**Consultation Response from KC,
Trees**

2024/91242 Land north east of, Shepley Road, Stocksmoor, Huddersfield, HD4 6XW

**Erection of residential development (up to 50 dwellings) with associated access, parking,
public open space, landscaping and infrastructure**

Date Responded: 12/06/2024

Figure 1:
Annotated Tree Retention Plan (11329-T-02 Rev C)

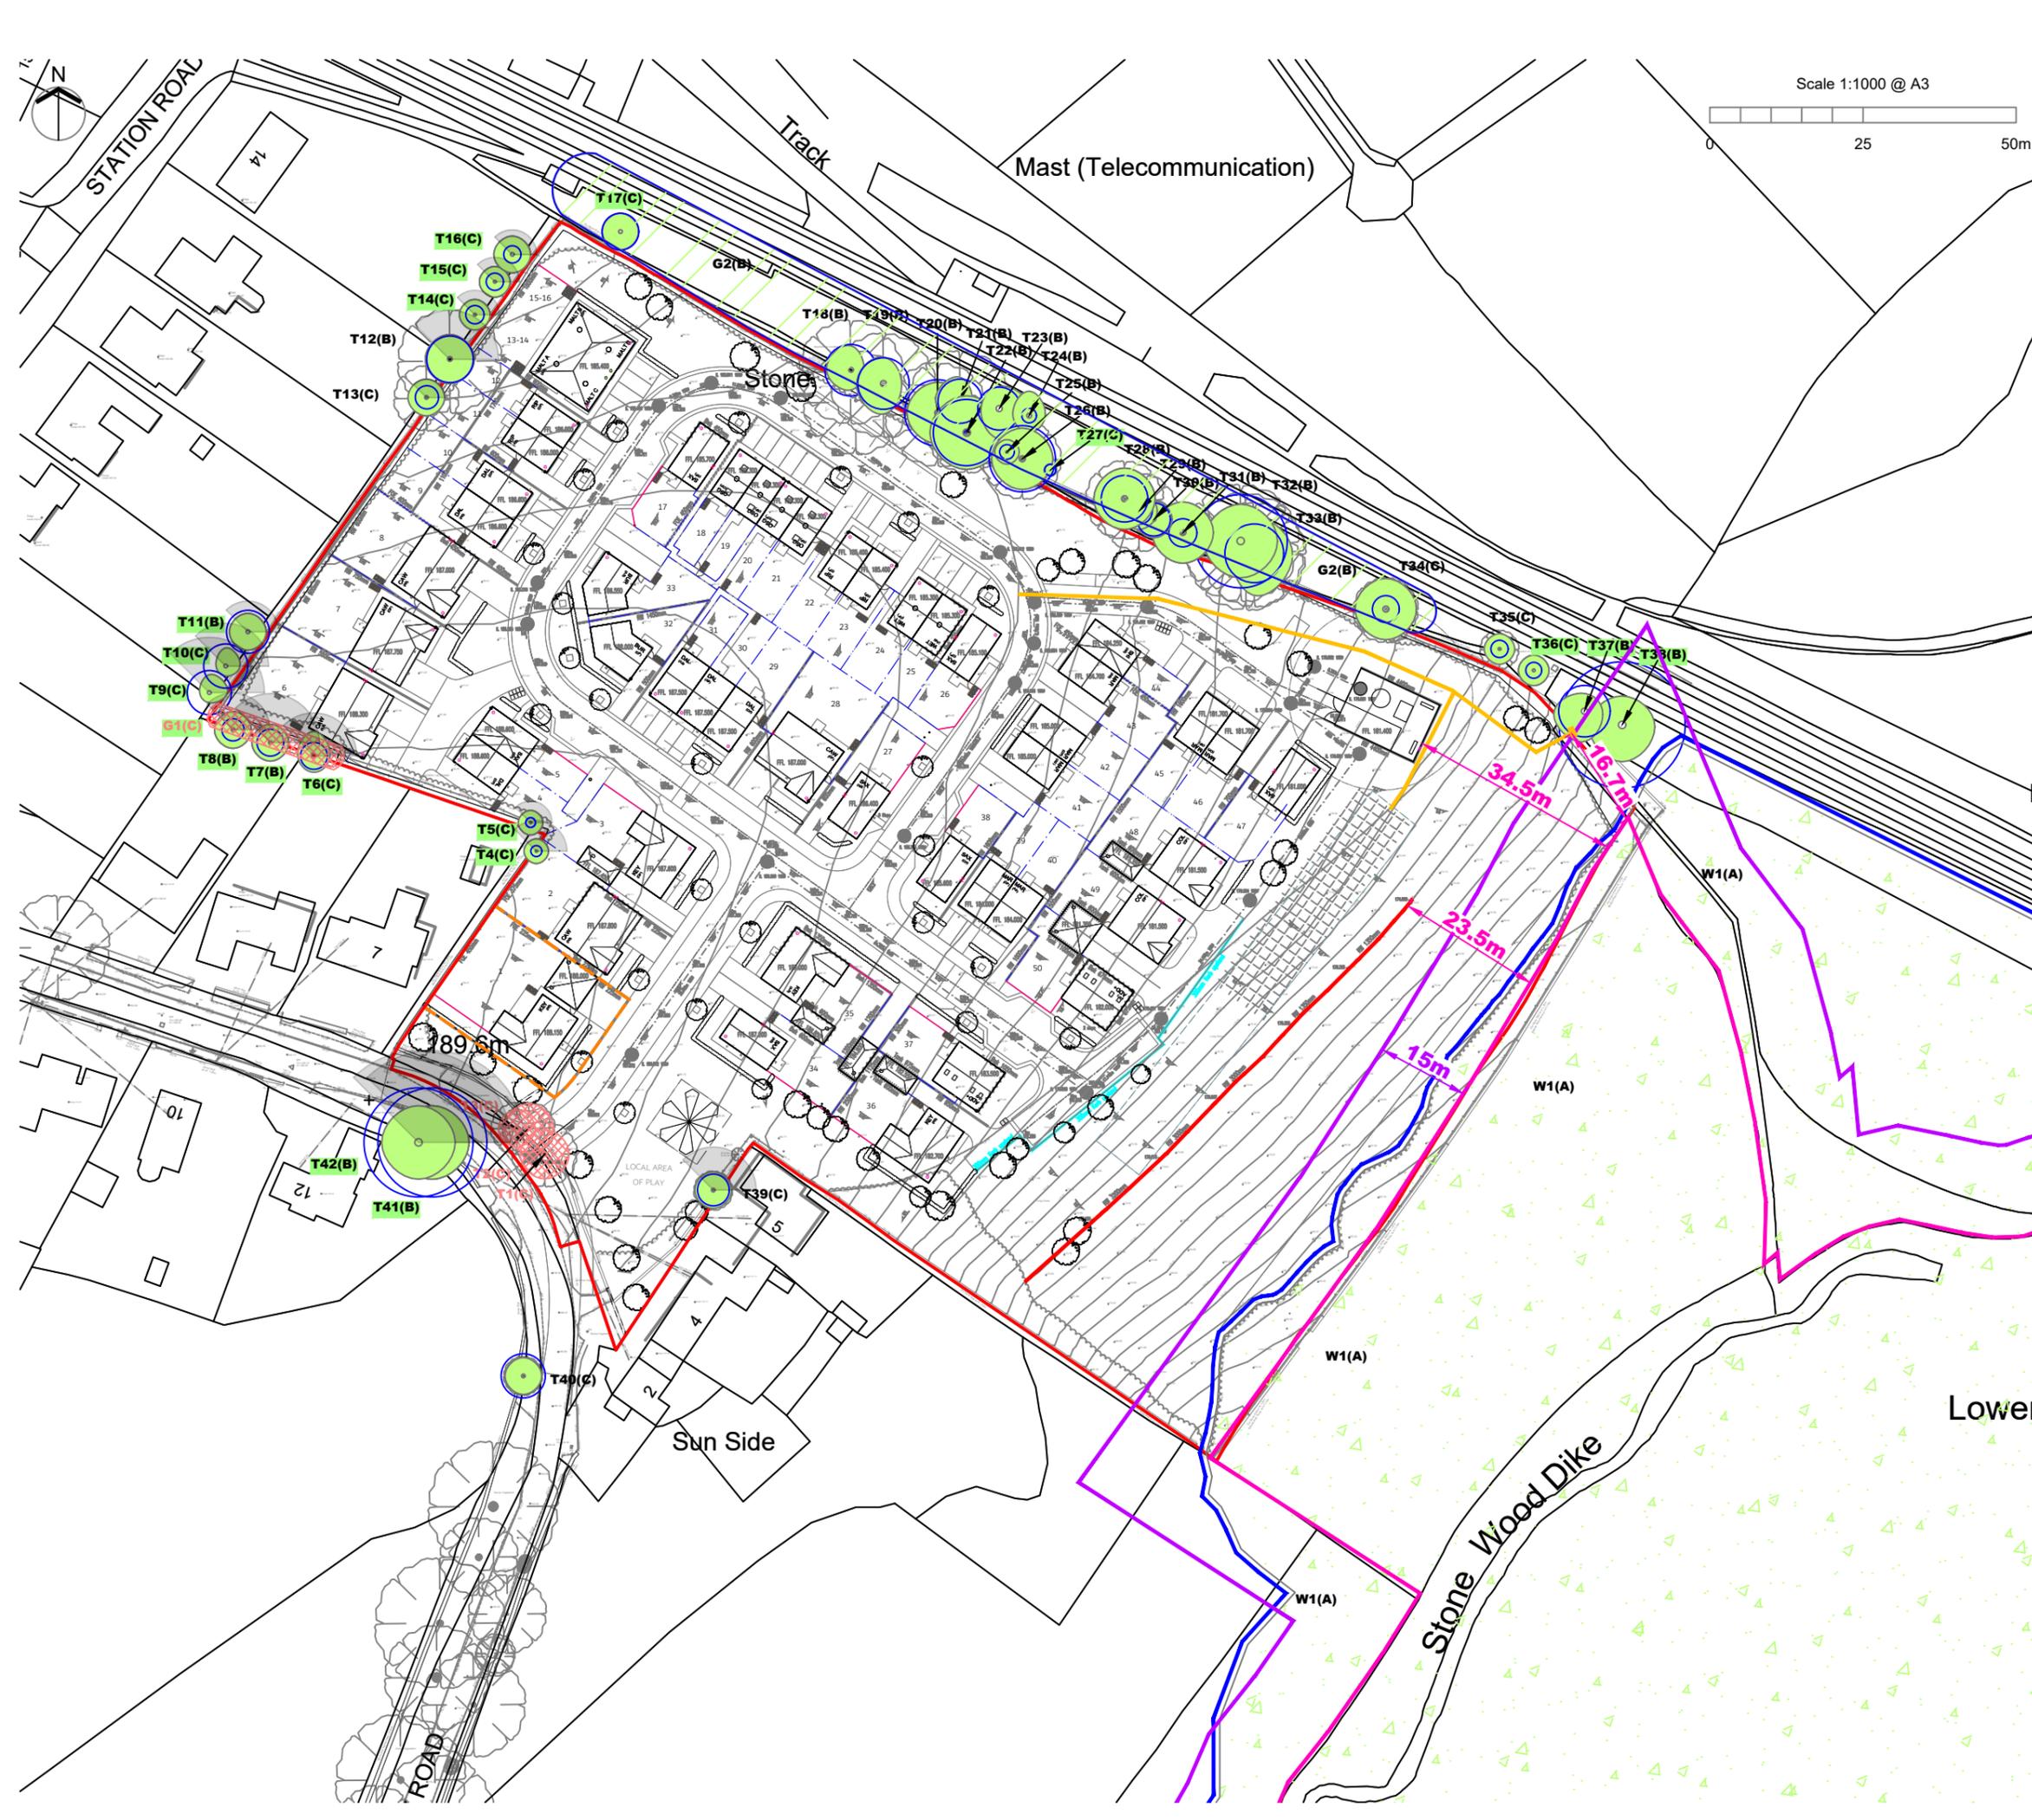
The design of this site is well thought out with regards to the current tree population. The submitted arboricultural impact assessment is thorough and makes valid recommendations. The removal of T1, T2 and T3 to facilitate the access road to the site is a tolerable loss due to their category C classification. Also, the loss of these trees can be mitigated through the new planting suggested. The design is a sufficient distance from the ancient woodland to the east that there should be no impact whatsoever.

There are no objections to the proposals under the condition that a site-specific, arboricultural method statement is submitted to accurately show the steps that will be taken to ensure no trees are damaged or harmed during construction.
